**Application no: 21/01630/OUT**

**Location:** Land at North West Bicester Home Farm, Lower Farm and SGR2 Caversfield

## Transport Schedule

Table 4-2: Amenities in Proximity to the Application Site

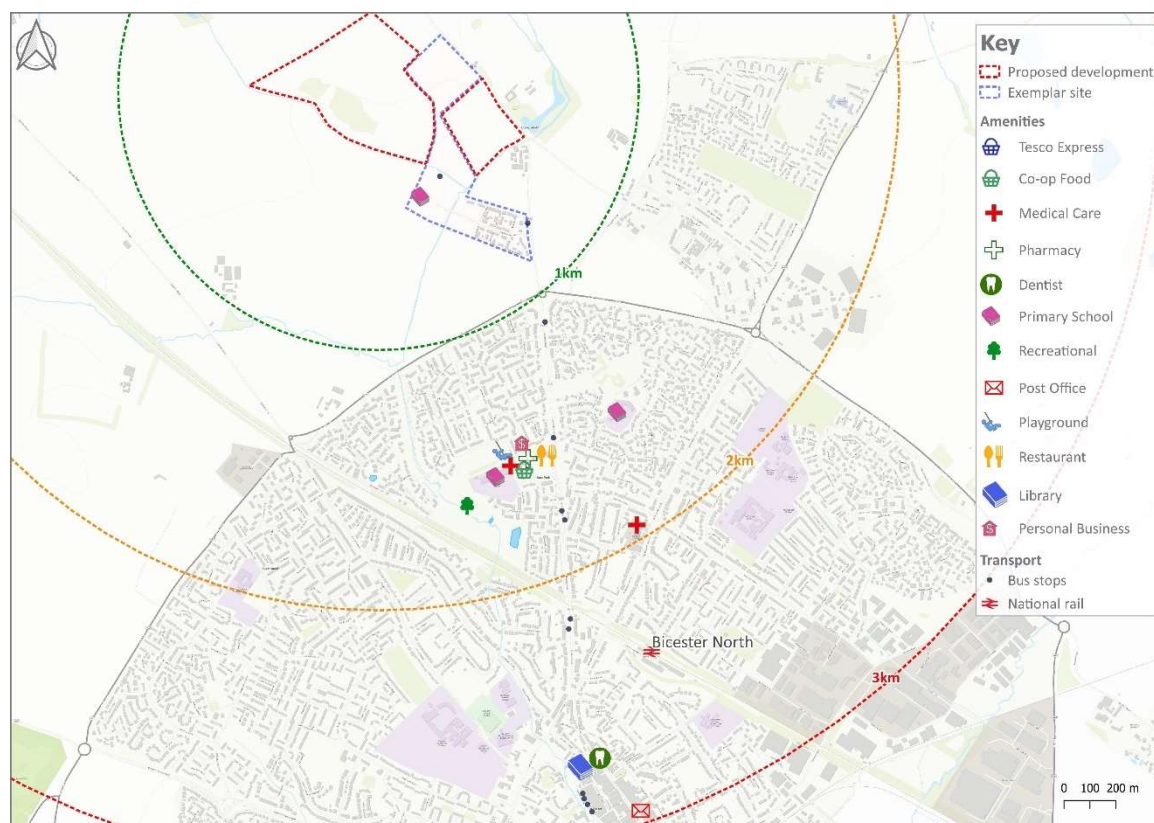
Some of the information in the TA is inaccurate in terms of distances to local facilities, giving the impression that the site is more accessible by sustainable transport than it actually is. For example, the distances in Table 4.2 don't correspond with the plan showing distances. The nearest shops are beyond the acceptable walking distance. At 4.5 the description of rail services does not show how some of the London services are now routed to Bicester Village instead of Bicester North. The TA also claims that there is a continuous off carriageway cycle route to Bicester North station, which is not the case. Even with the planned improvements to the roundabout at the B4100/A4095 junction, there is still a substantial gap in safe cycle provision on Banbury Road. **Reason for objection**
